MODIFICATION REQUEST:

**92, Manning Street, Tuncurry.
7 storey Commercial/retail building Lot 1 DP
301489. MP08_0042 (Mod.2).**

Director-General's
Environmental Assessment Report
Section 75W of the
Environmental Planning and Assessment Act 1979

March 2012

SOUTH ELEVATION
SCALE 1:200

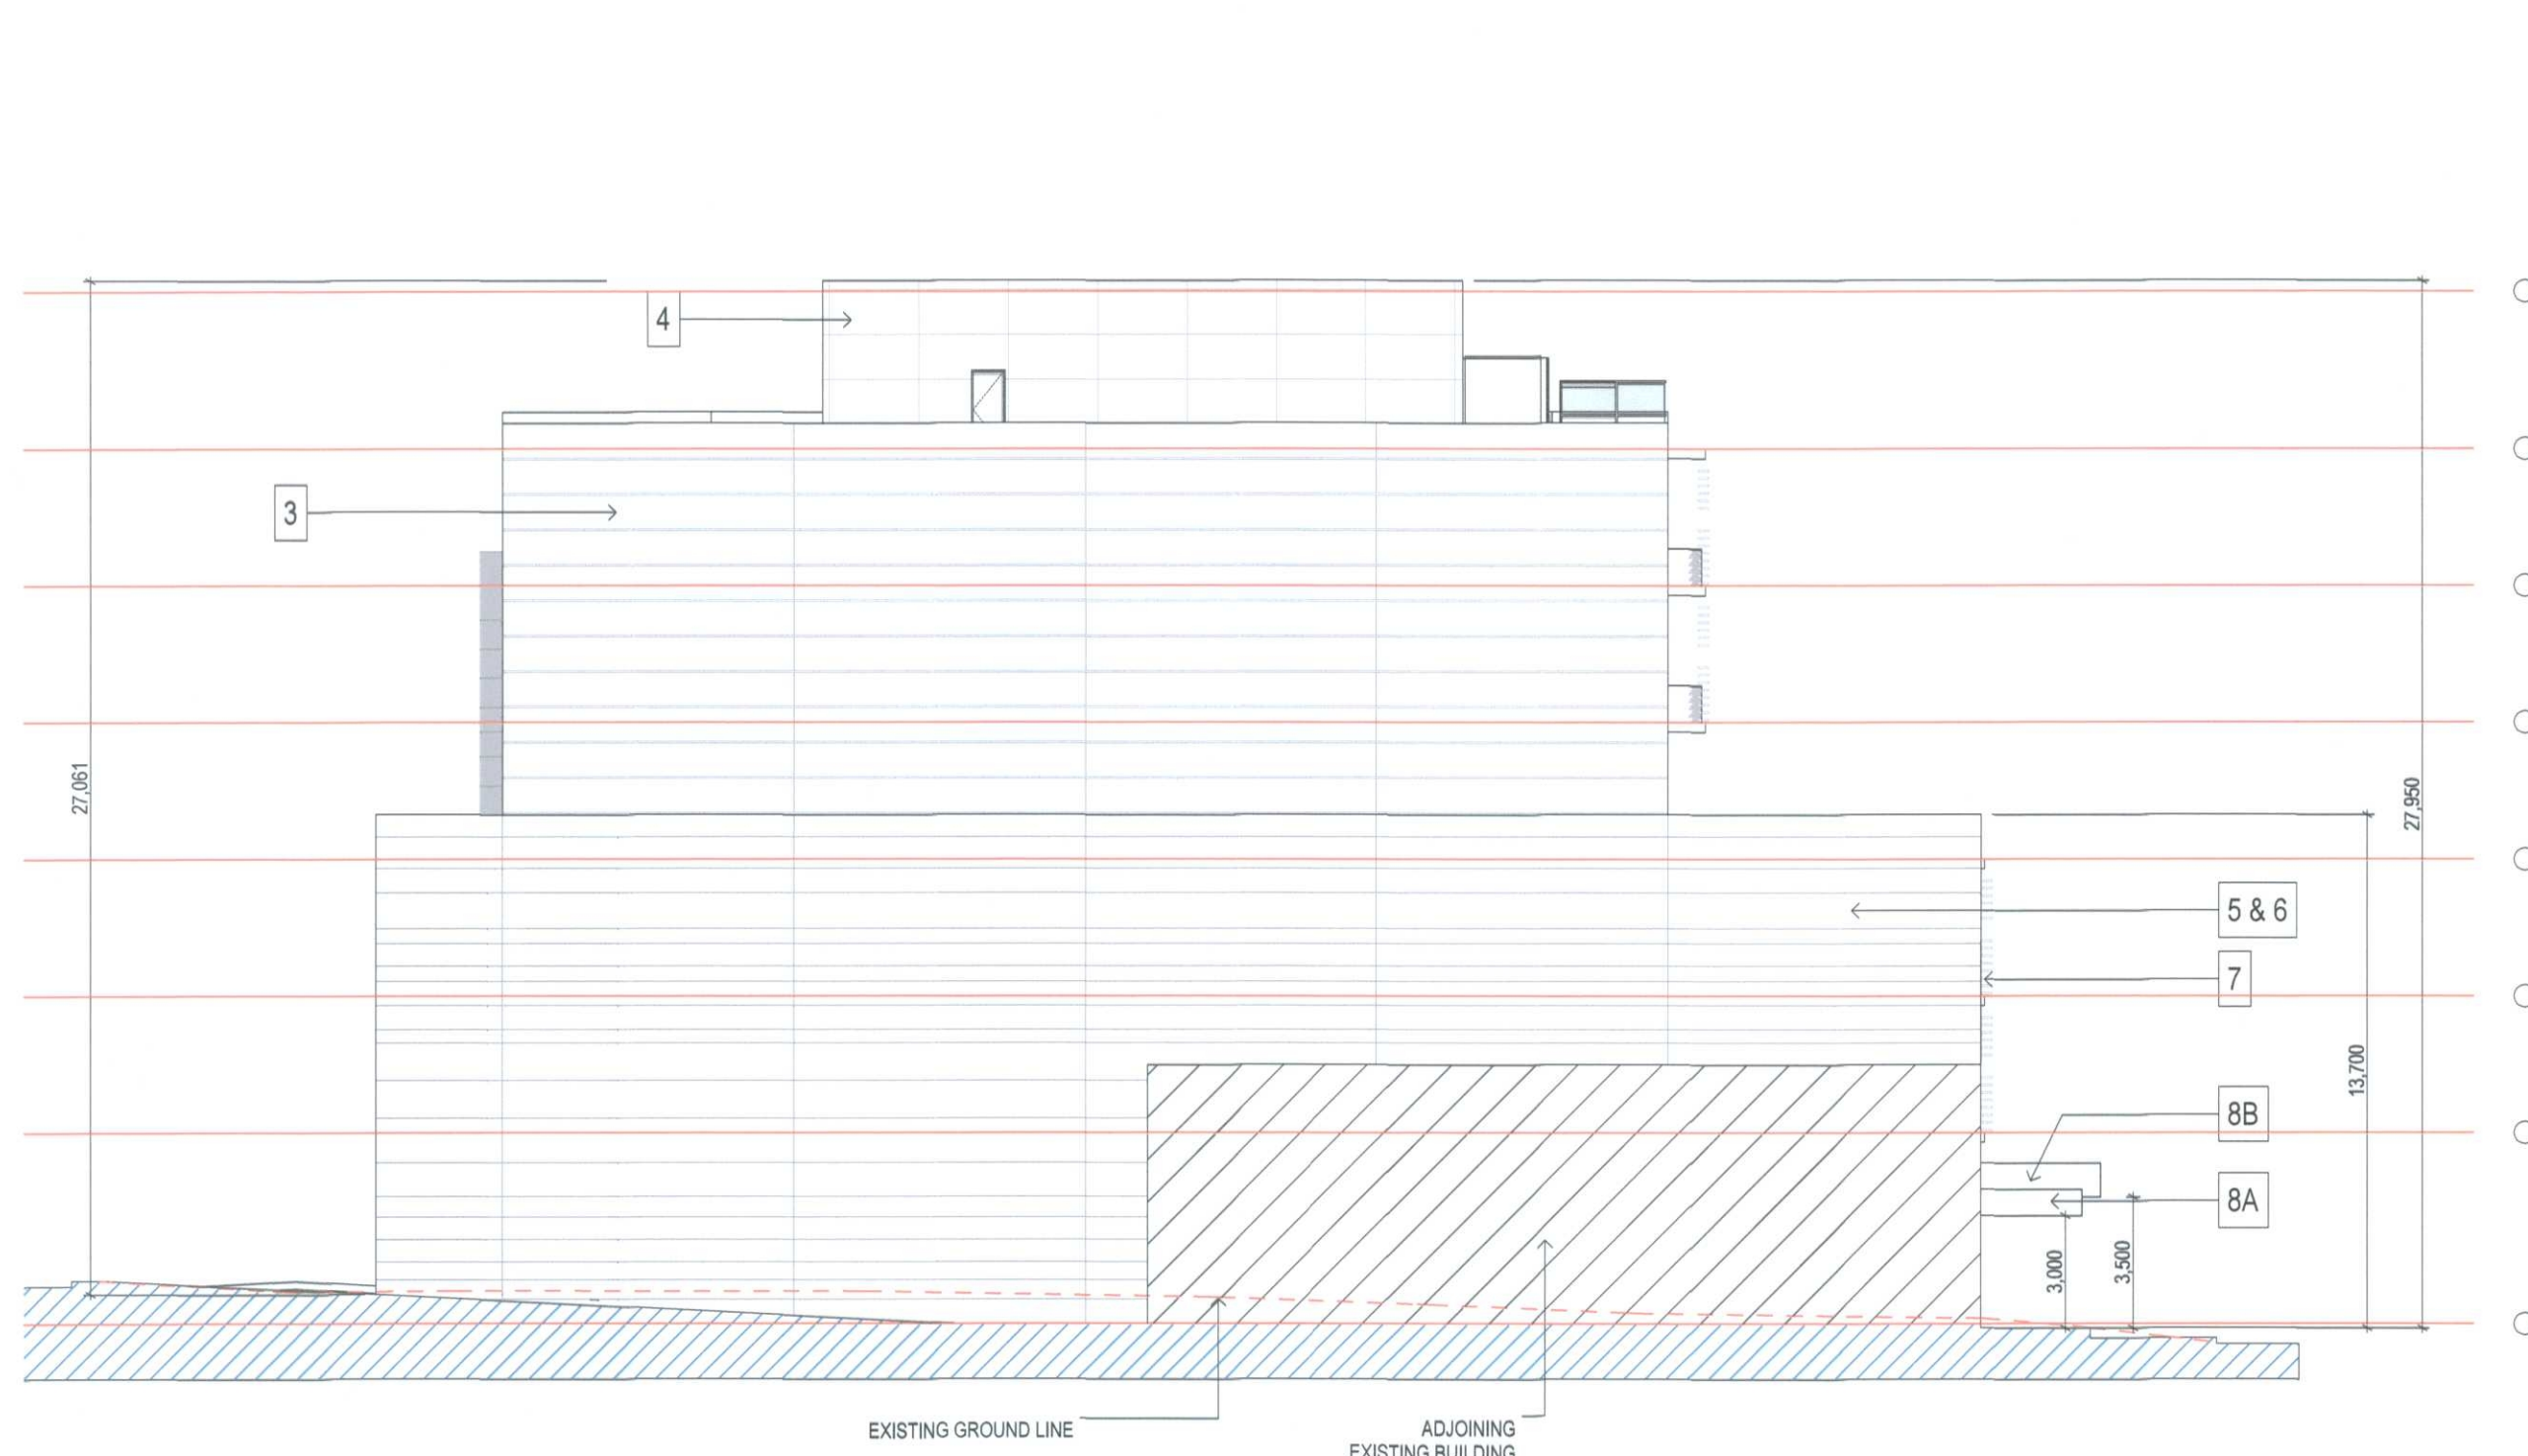
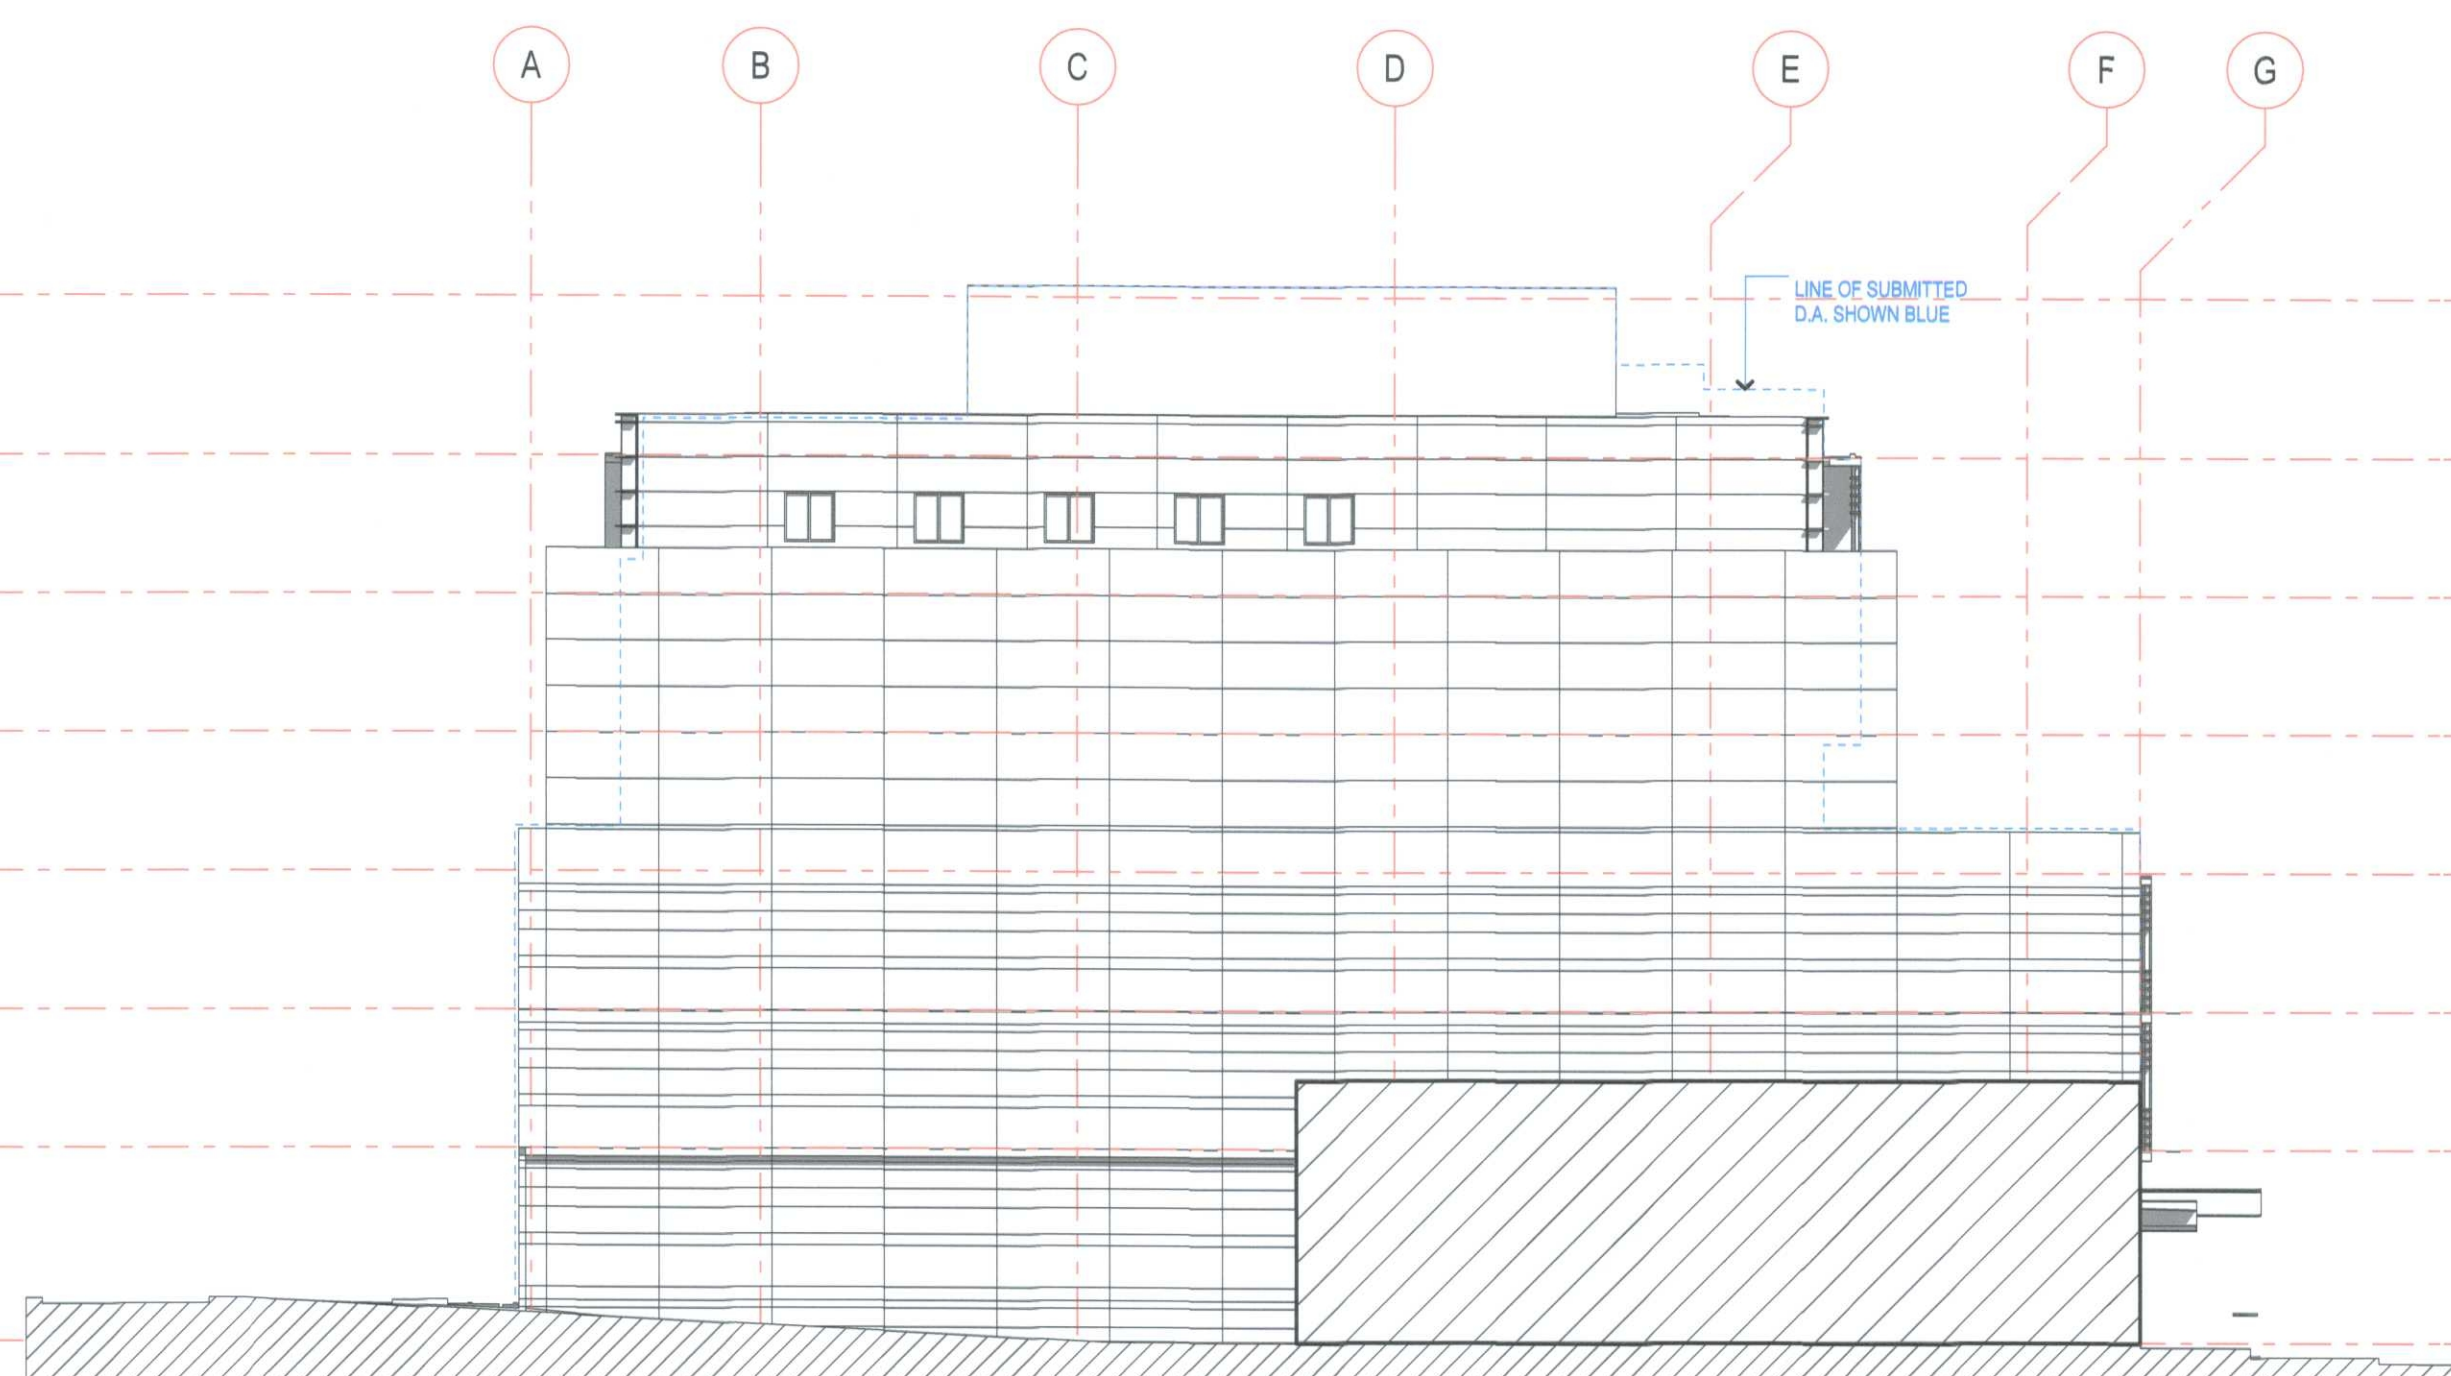
Great Lakes Council by response dated 6 January 2012 advised that the plant room was undefined in the modification plans and that new windows near the side boundary on level 6 require possible contingency treatment to maintain future privacy and neighbouring site redevelopment equity. These issues have subsequently been resolved by the submission of the plant room plans and the imposition of new condition F23 (see Table 2 below) which satisfy council's concerns.

Issue	Consideration
<p>1. New windows are proposed near the side boundary on level 6 (item f, Table 1).</p> <p>This requires a contingency to allow for their treatment to maintain future privacy and neighbouring site redevelopment equity.</p> <p>Planning Control: DCP51 setback requirements (Clause 15.7, Table 15.1):</p> <p><i>9 metres where a habitable room/balcony faces a habitable room/balcony on an adjacent property</i></p> <p><i>6.5 metres between habitable rooms/balconies and non habitable rooms/balconies on an adjacent property</i></p> <p><i>4.5 metres where a non-habitable room/blank wall faces a non habitable room/blank wall on an adjacent property</i></p>	<p>Generally, the setback controls specified in Table 15.1 of DCP 51 would require a side wall incorporating windows to be setback up to 9 metres. The approved southern blank wall on level 6 was setback 0.725 metres by virtue of condition B1, essentially to improve the urban design of the upper levels of the building.</p> <p>The DCP height controls allow construction of a building of similar or even greater height, on neighbouring sites in the future. Therefore it is necessary to consider the implications of future development potential of neighbouring sites. Note that in DCP 51, sites having width less than 30 metres are restricted to 4 storeys.</p> <p>Setbacks are also normally required in order to preserve future privacy because a presumption exists that a future redevelopment may incorporate a residential use with windows facing the proposed windows. The setback controls are also aimed at maintaining a level of equity between adjoining sites so that neither is disadvantaged in terms of development potential by allowing the excessive "borrowing" of window amenity from its neighbour. Therefore when windows are placed within the specified side boundary setbacks, the windows must be unrequired (by the BCA, in terms of light and ventilation) and be capable of being treated so that they also allow suitable privacy and amenity objectives to be achieved for any future residential development on the adjoining site</p> <p>The proposed windows are unrequired. Therefore, the proposed side elevation windows will be regarded as a temporary opportunity for occupants to enjoy views from the side of this commercial building. The most appropriate means to control these windows is to provide for a condition to require a covenant to specify that the side boundary windows to be made suitable for, and, if necessary, deferring to, a future development at the time when this occurs on the neighbouring site. The covenant will require the windows to be treated or replaced (if necessary) with chemically or mechanically etched glass so as to eliminate any privacy concern, if needed to mitigate privacy or achieve development density capability, in the redevelopment of the neighbouring site. The accepted method is to provide for a S88(B) covenant in favour of the Council.</p> <p>The Council should regard the covenant as a discretionary tool whereby the Council can enforce its design intent to achieve a reasonable planning outcome for the neighbouring site, if such enforcement is indeed required (given contemporary development controls). The covenant should be maintained for so long as the building which has the covenanted windows continues to exist.</p>

Issue	Consideration
2. Urban design consideration of new windows on the southern elevation (item f Table 1).	<p>The proposed new side windows to the southern elevation of level 6 are a positive urban design element that helps to reduce the massing of what will be a quite prominent building in Tuncurry, pending new developments of a similar scale in this precinct in the future.</p> <p>There is merit in allowing additional articulation of a façade through introduction of windows, wherever possible, especially when there may be an extended period of time that a building such as this one may feature prominently within the townscape. This is also consistent with the objectives of Clause 9 of DCP 51.</p>

The proposed modifications are acceptable, subject to a new condition F23 for a covenant to require future treatment (privacy etching or frosting) of the windows at level 6. The covenant would only be enforced to maintain future equity and privacy of neighbouring property on its redevelopment.
